DATE: October 6, 2014  
TO: Jack Cloud, DRB Chair  
FROM: Catalina Lehner, Senior Planner *CL*  
RE: Project #1010180, PNM La Morada Substation  
Site Development Plan for Building Permit

On September 11, 2014, the EPC voted to approve a site development plan for building permit for an approx. 3.2 acre site located on Vista Oriente Rd. NW, east of Unser Blvd. NW and north of Ladera Dr. NW.

Staff reviewed the September 30, 2014 version of the site development plan for building permit and notes the following, minor issues:

SOUTH DRIVEWAY DETAIL

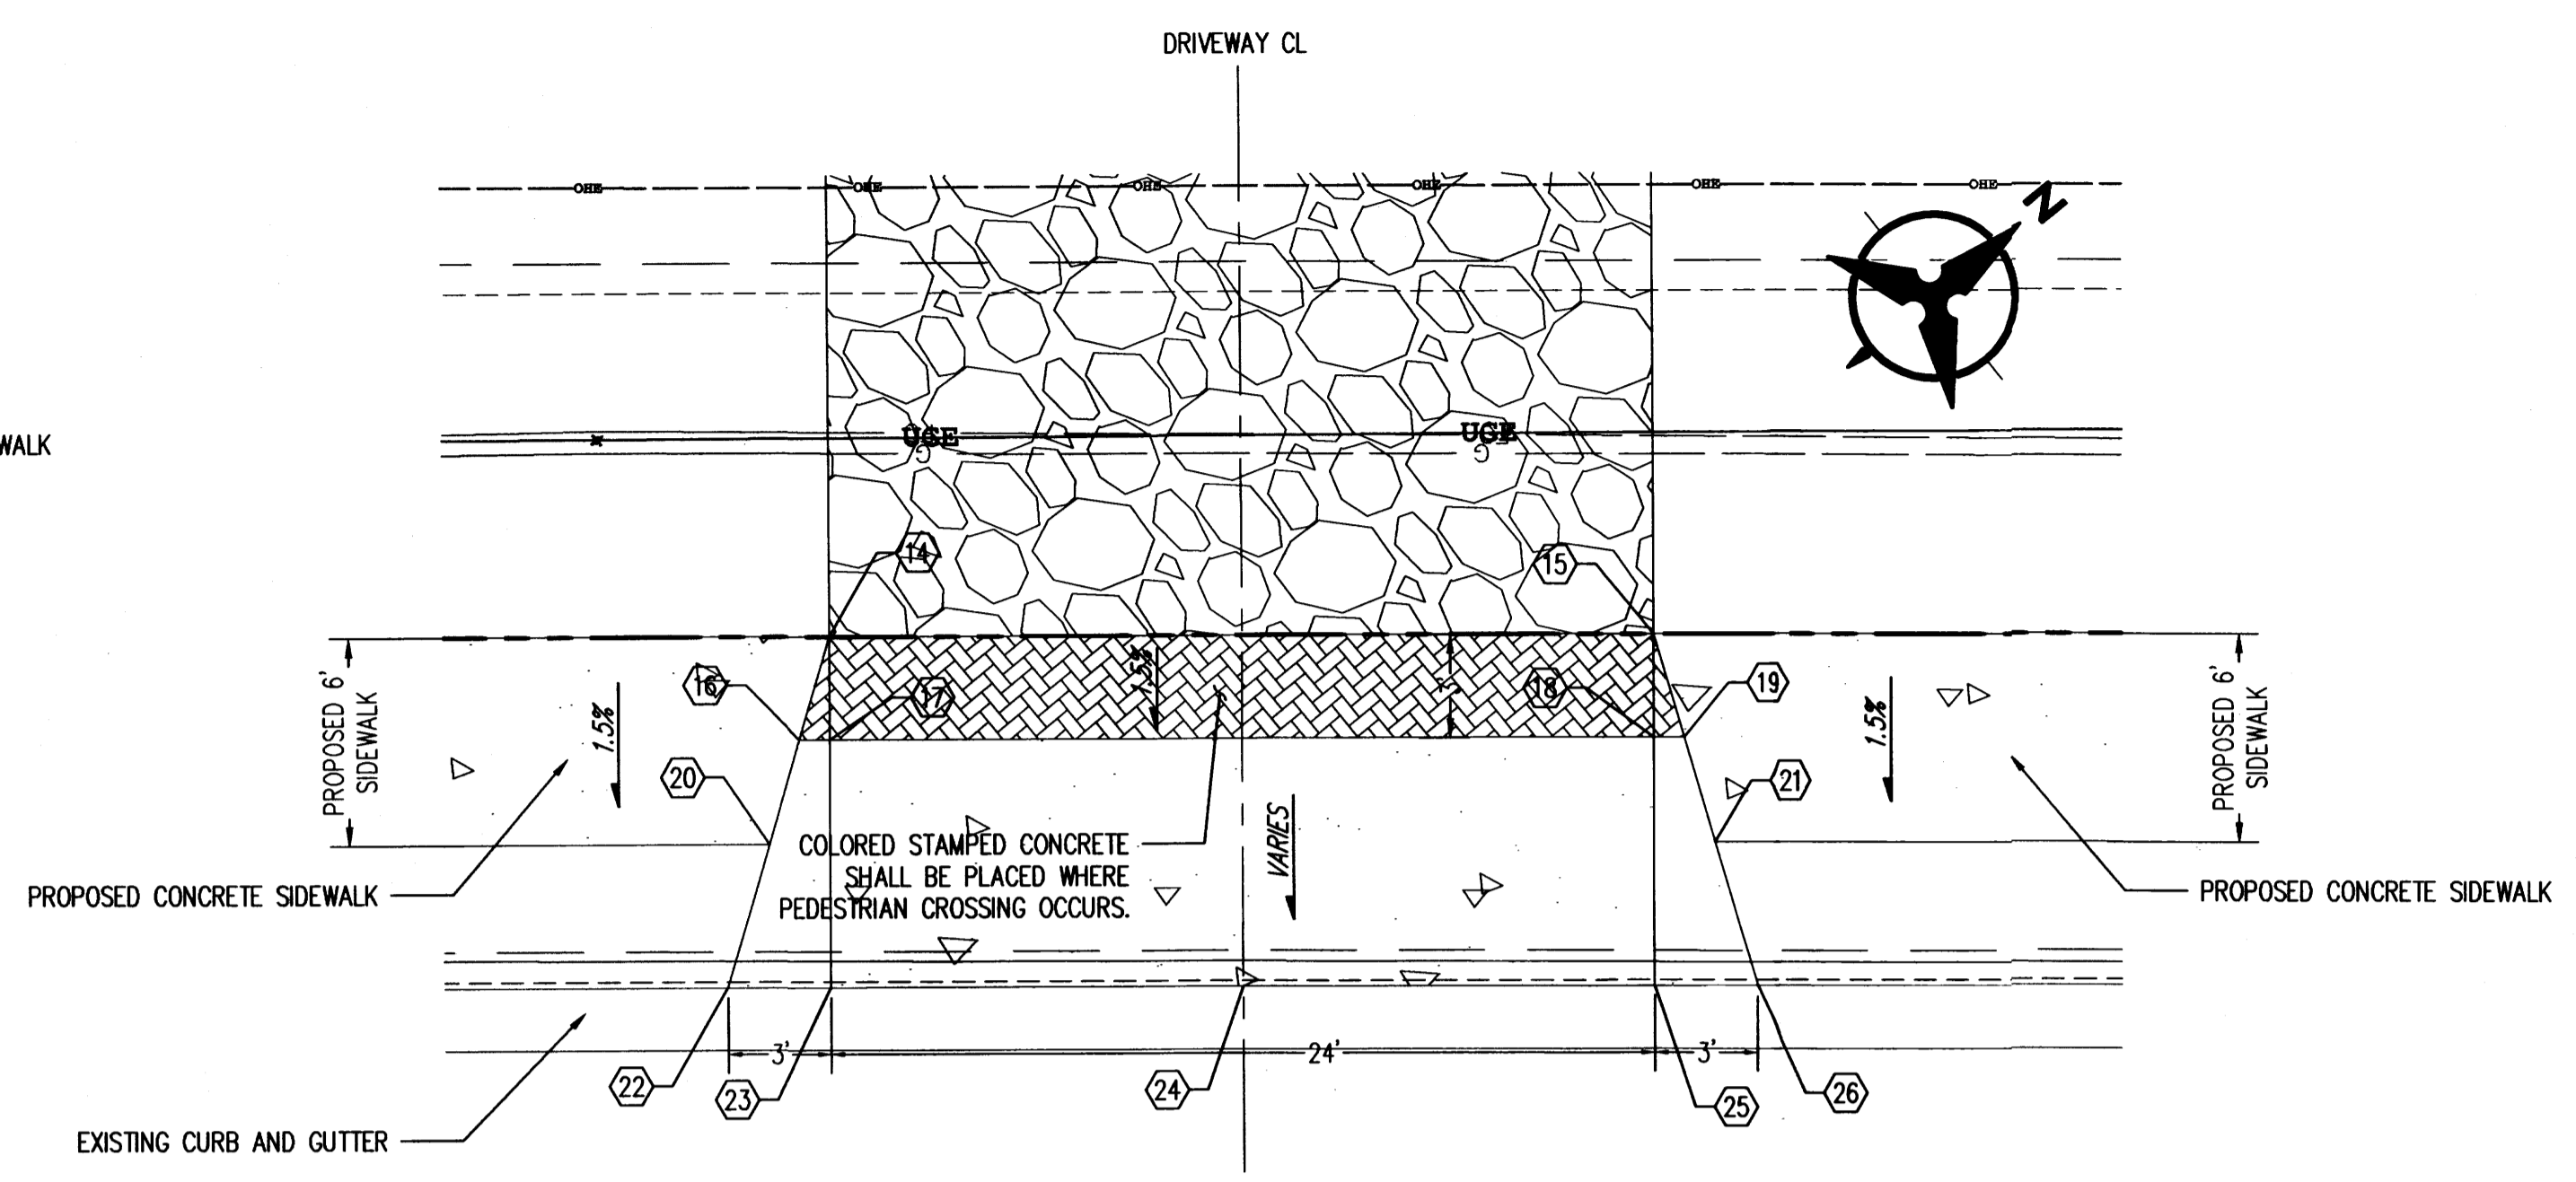
Condition 7C: Add a different symbol for the textured, colored concrete as is crosses drive-aisles. It should not look the same as the symbol for plain sidewalk.

WALL DETAIL

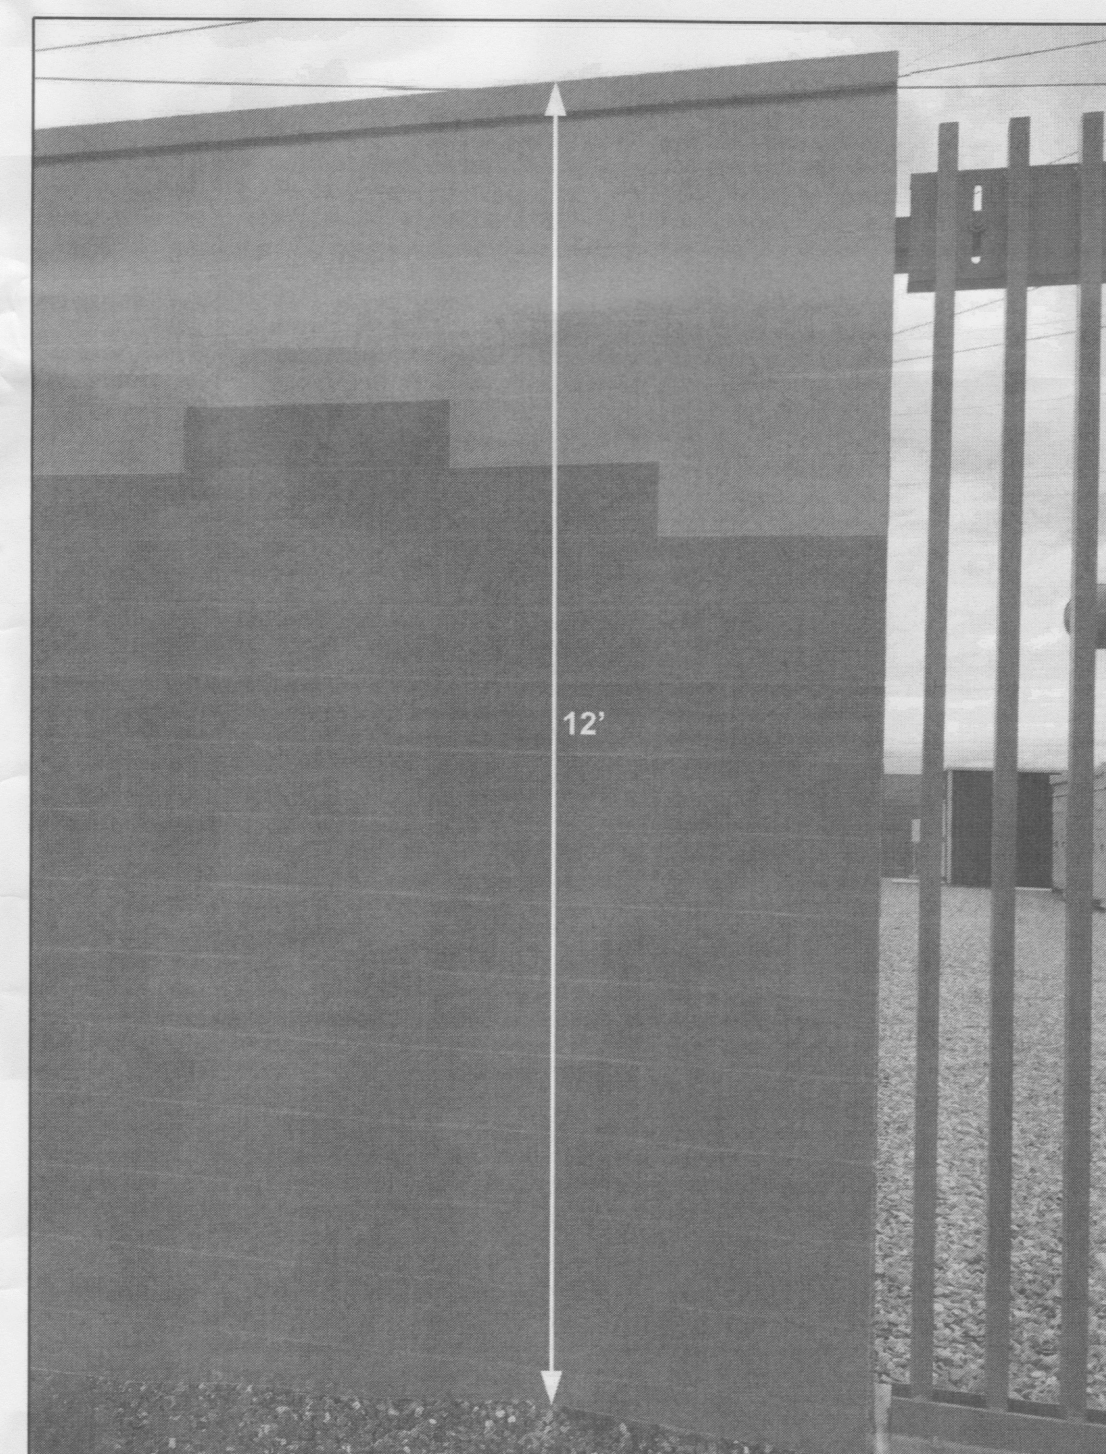
Condition 5A: Add an A and a B to the wall detail to specify materials and colors (A & B correspond to the legend).
